Application number: 2022/93579	
What is the application for?:	Variation of condition 2 (plans) on previous permission 2021/90300 for erection
Address of the site or building:	Freckleton A, Bristfield Road, Bristfield, Dewsbury, WF12 0NX
Postcode:	WF12 0NX

BASEMENT
 as proposed
 Scale 1:50 @ A1
 Demolition
 New walls
 New structure to be designed by Structural Engineer

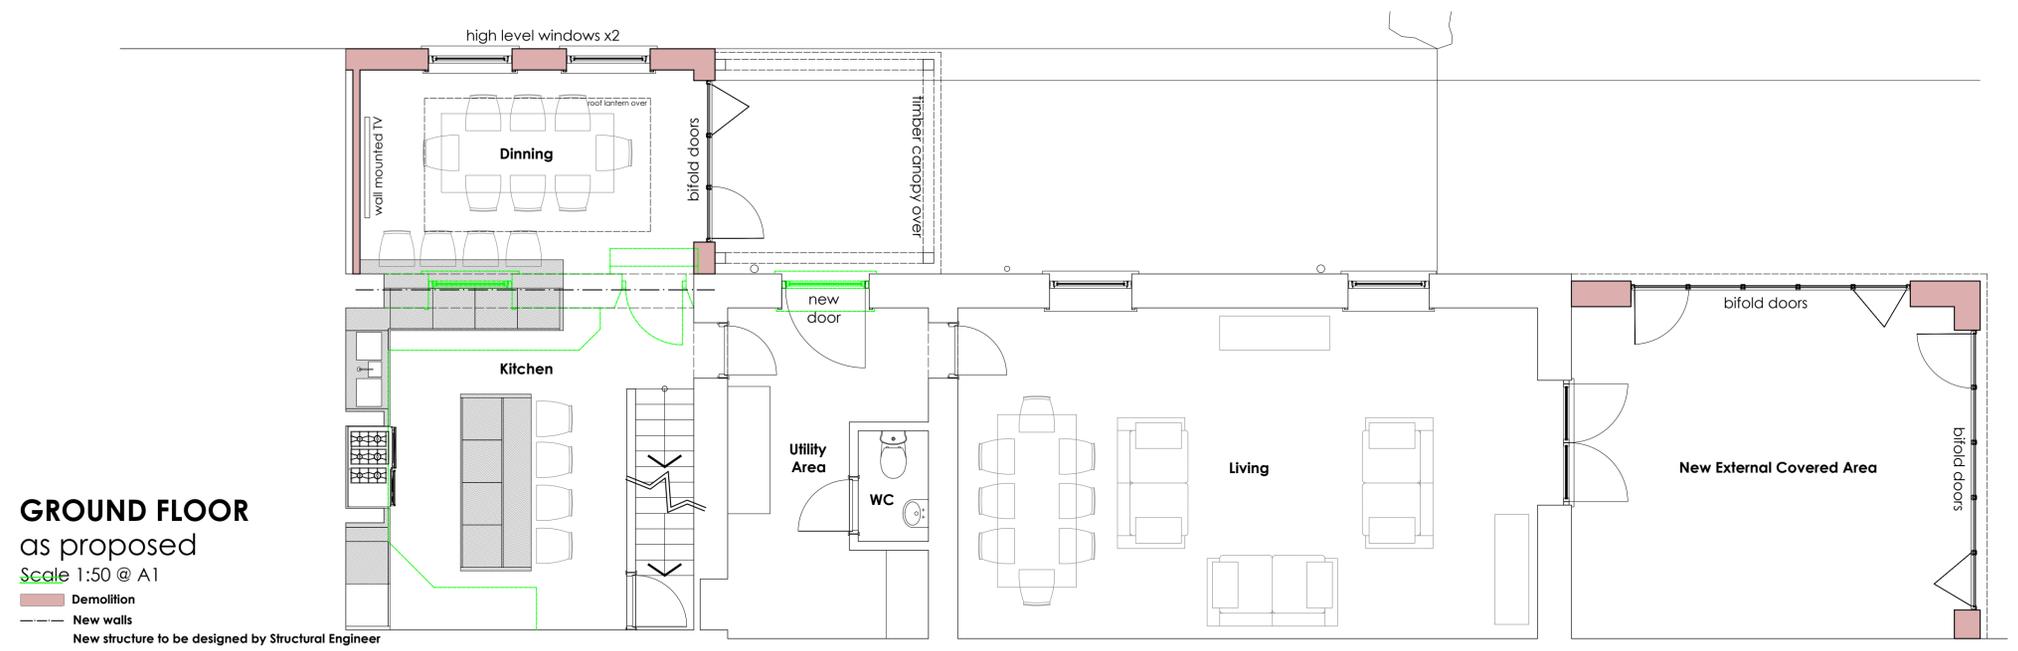
Type of comment: An objection	
Do you wish your comments to be published on the website anonymously?	Yes
Window in cellar is invading privacy into neighbouring property as it is directly on the boundary wall looking into neighbours property. also new cellar has no permission or plans but has been built undear the new kitchen extension already also boundary wall footings have been placed on neighbouring properties land.
